WEST SUSSEX COUNTY COUNCIL CONSULTATION

TO:	Arun District Council FAO:M Tomolova
FROM:	WSCC - Highways Authority
DATE:	3 February 2022
LOCATION:	The Hatters Inn 2-10 Queensway Bognor Regis PO21 1QT
SUBJECT:	BR/294/21/PL 3 storey upward extension and redevelopment of the existing 1st and 2nd floor delivering 43 no flats. This application may affect the setting of listed buildings, affects the character and appearance of The Steyne Conservation Area and is in CIL Zone 4 (Zero Rated) as flats.
DATE OF SITE VISIT:	n/a
RECOMMENDATION:	No Objection
S106 CONTRIBUTION TOTAL:	n/a / £ See below for breakdown.

PROPOSED BASEMENT PLAN
Sc. 1:100

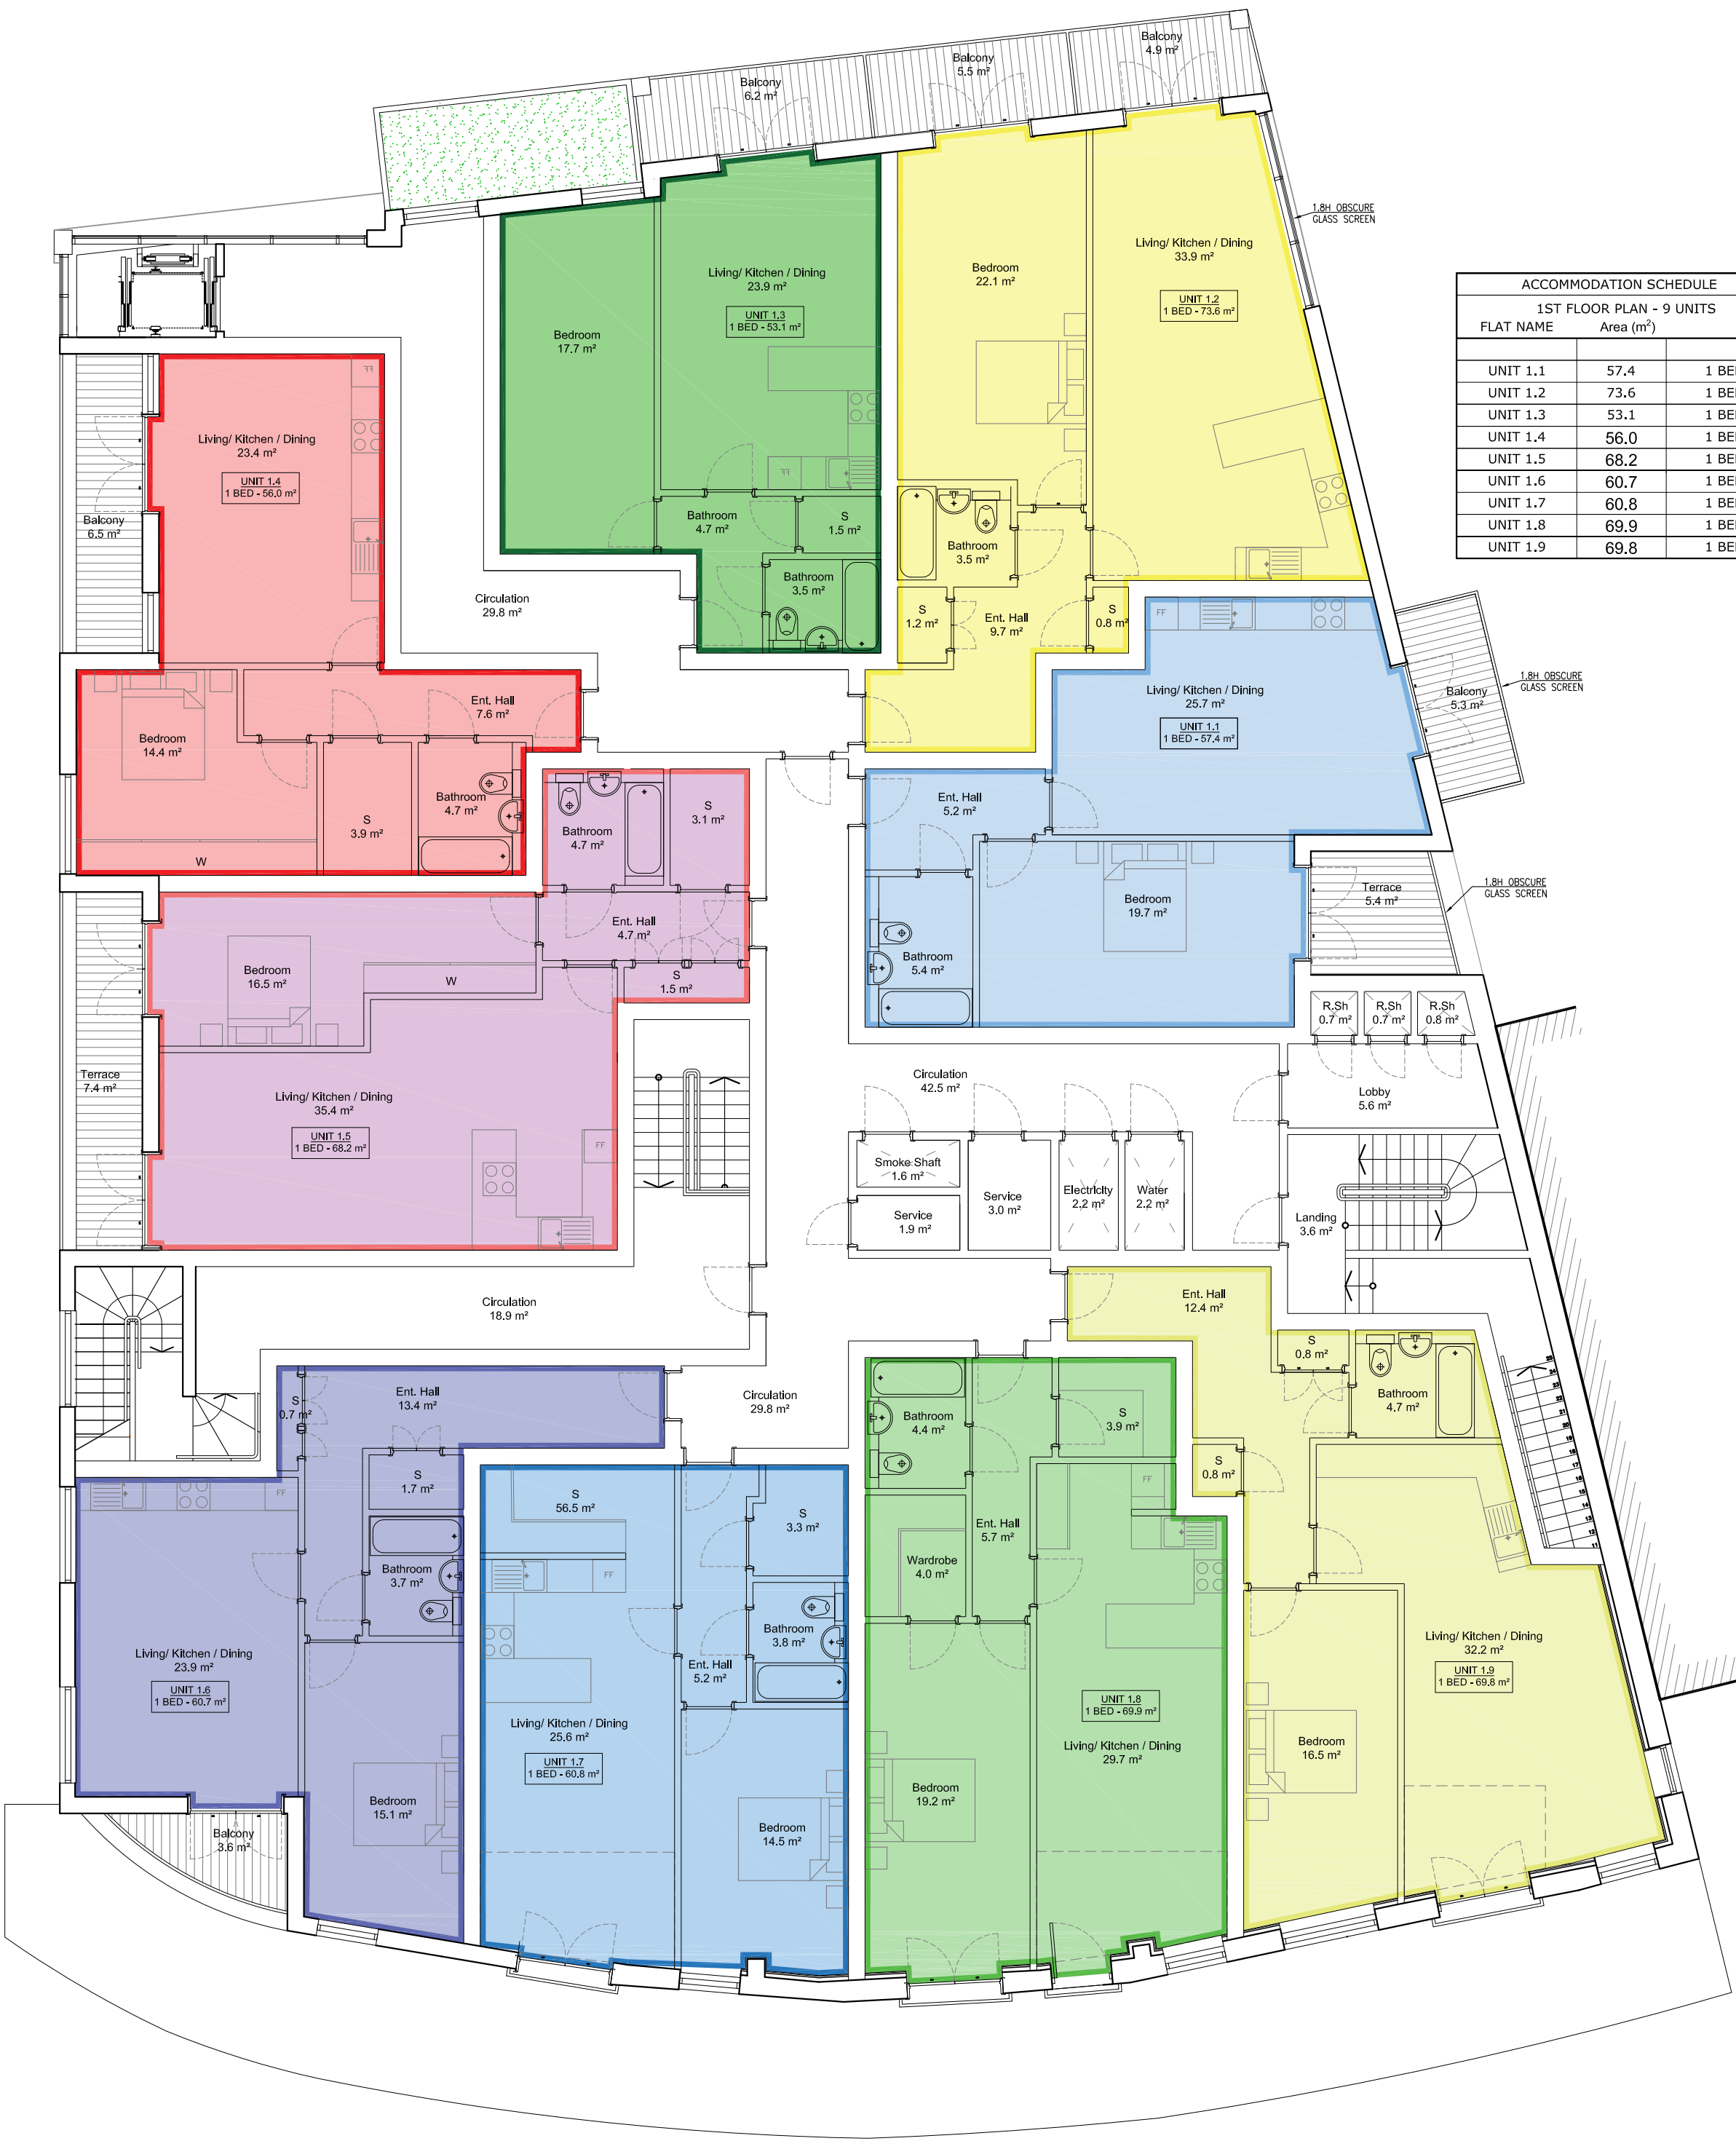
WSSC cycle parking standards for flats with communal storage are 0.5 space for 1 and 2 beds which equates to 24 spaces for 43 flats. We would recommend a reduction in the number of spaces currently provided (52). This is to ensure better cycle stands are fitted into the space. Sheffield hoops are preferred over the use of two- tiered varieties as they are more user friendly.

If the applicant can provide space for 24 cycles using Sheffield stands this would be our preferred choice.

Access into the basement will be via stairs from the footway on West Street. WSSC would advise the stairs are provided with a bicycle ramp strip on one side, or both sides to allow easy movement of any bicycles in and out.
